Comments made on behalf of Huddersfield Civic Society.

Huddersfield Civic Society notes that this application is for full planning permission by Redrow homes for 270 houses on part of site HS11 which is allocated for a total of 1460 houses. We ask that permission is refused on numerous grounds including:

TITLE: **PROPOSED SITE LAYOUT**

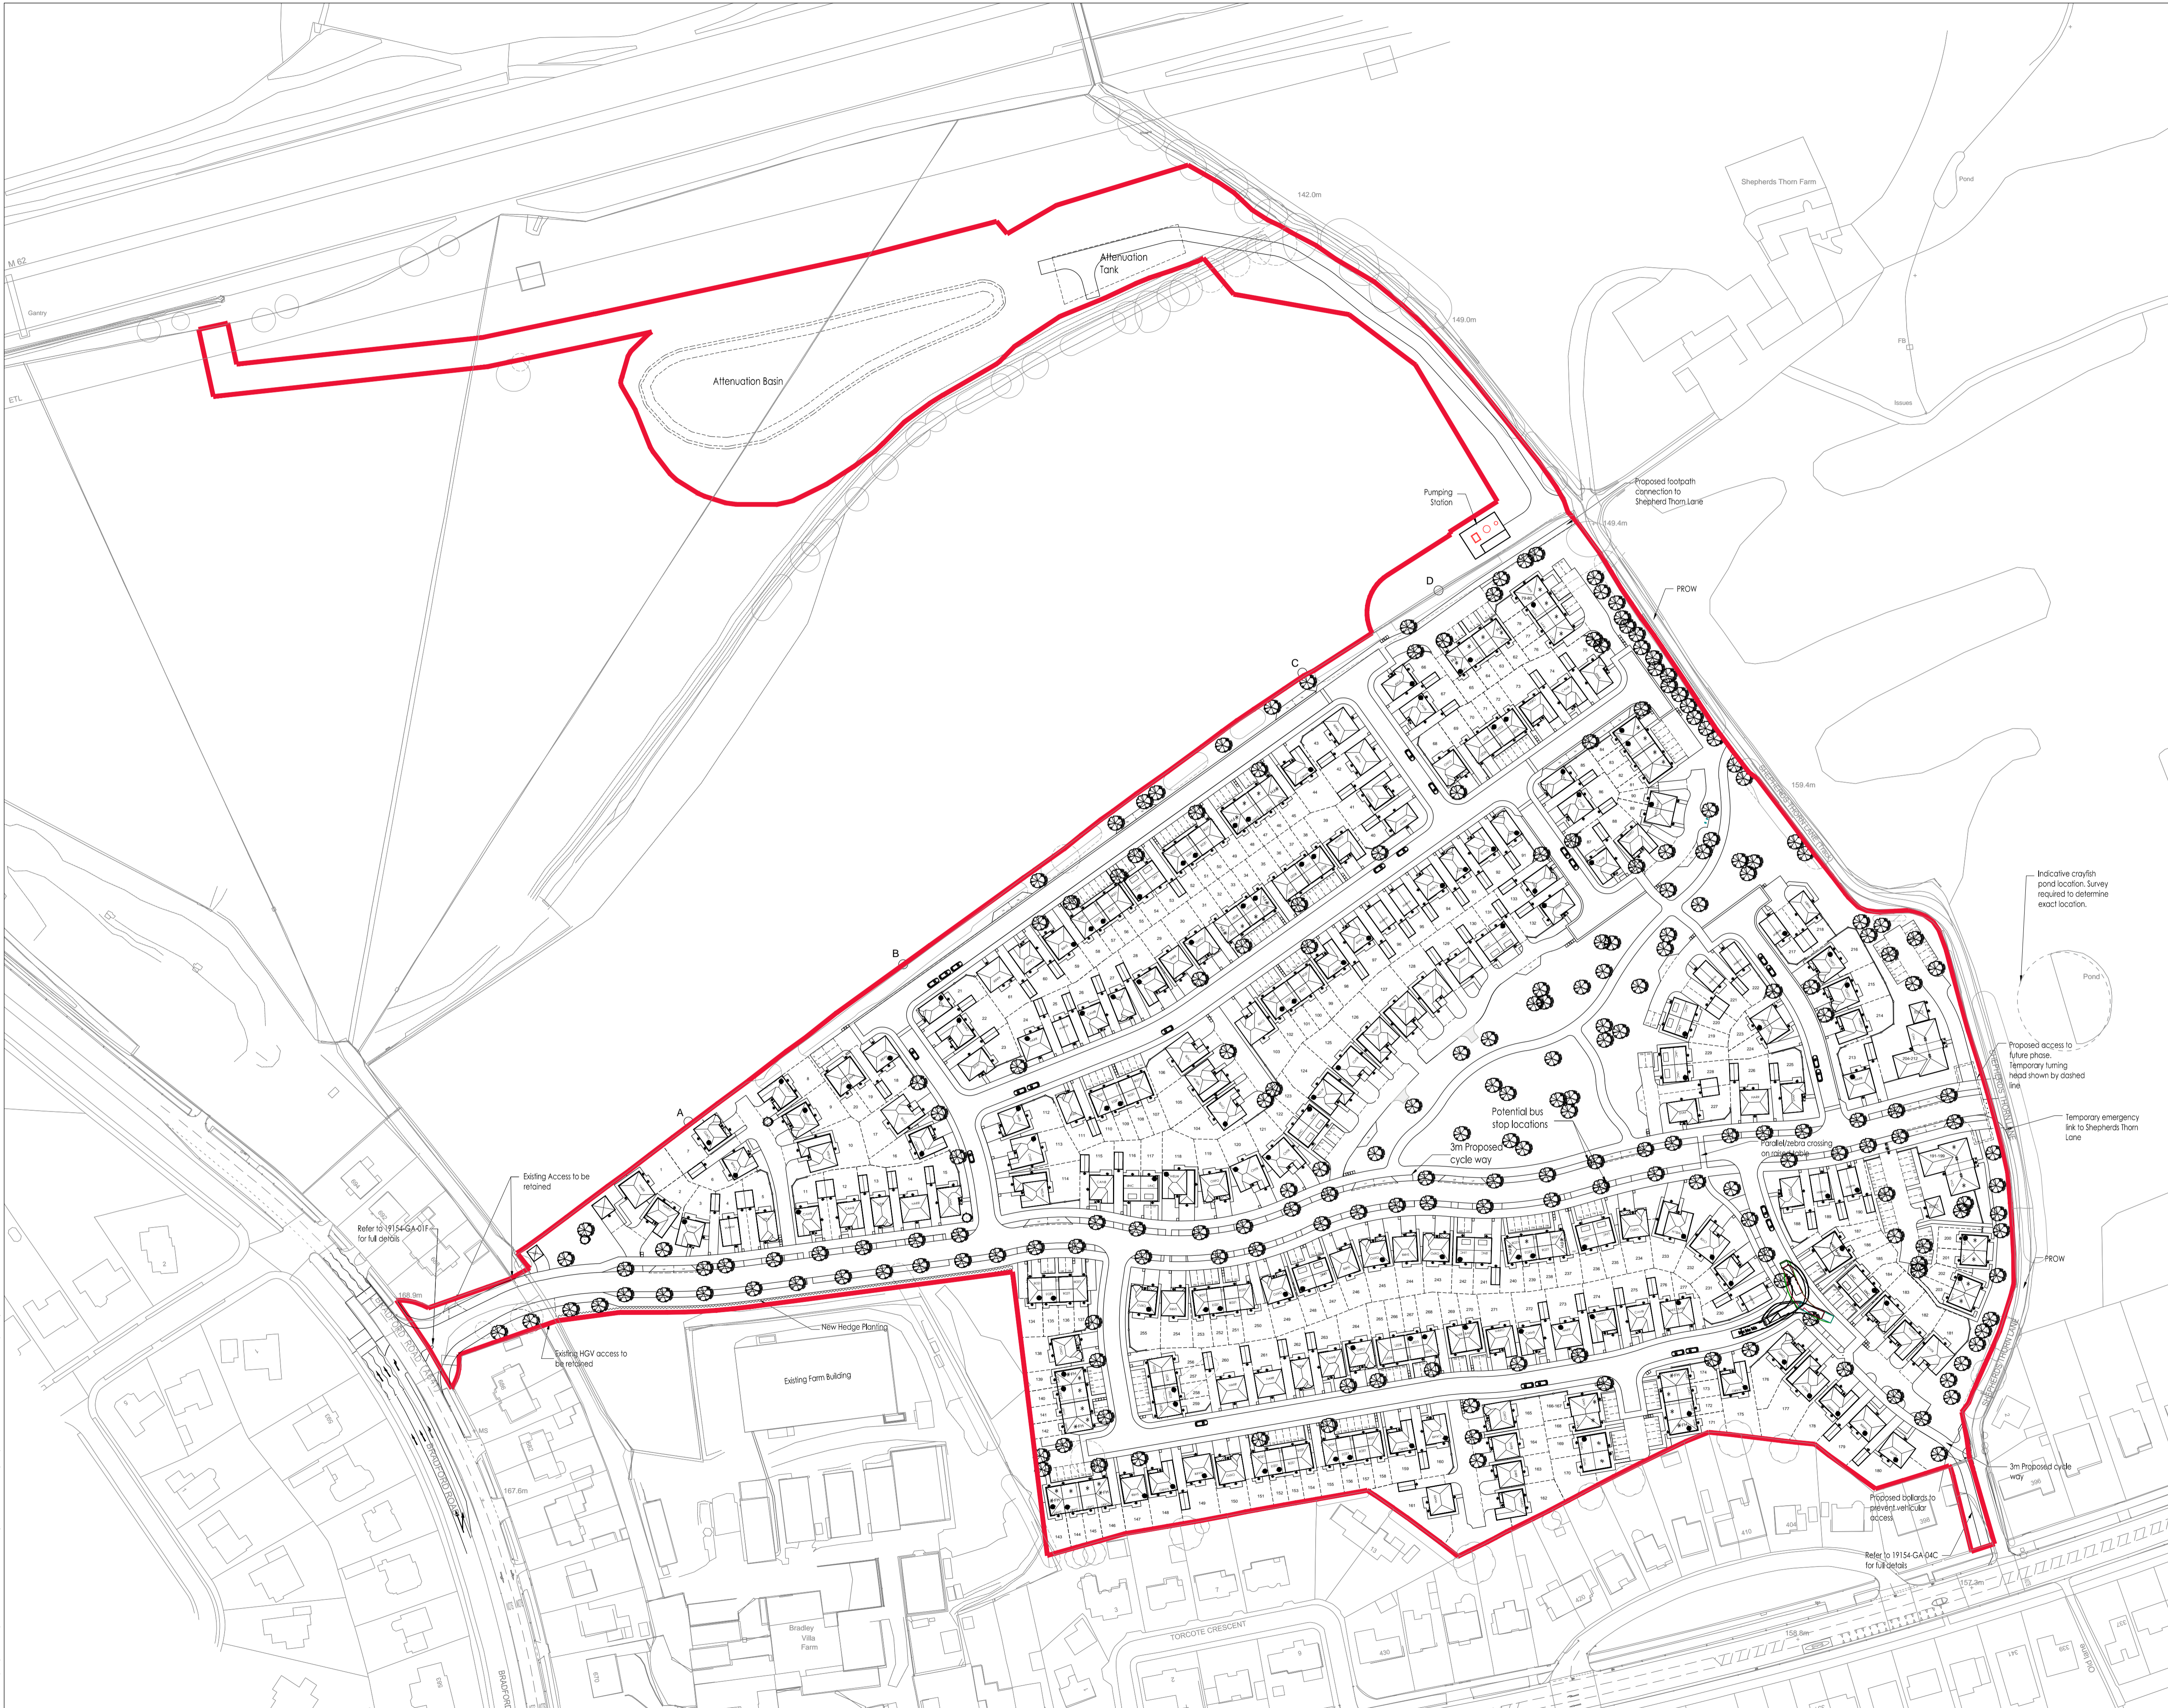
- That the layout, in consisting largely of cul-de-sacs with variably oriented houses and traditional roofing, takes inadequate account of opportunities to maximise solar gain and photo-voltaic generation

- That this is a car-based development with 550 off-road parking spaces and inadequate provision for walking and cycling links, especially given the busy main 'A' roads that lie between the proposed houses and all existing local facilities, such as schools, shops, surgery, community centre and employment at Bradley Business Park
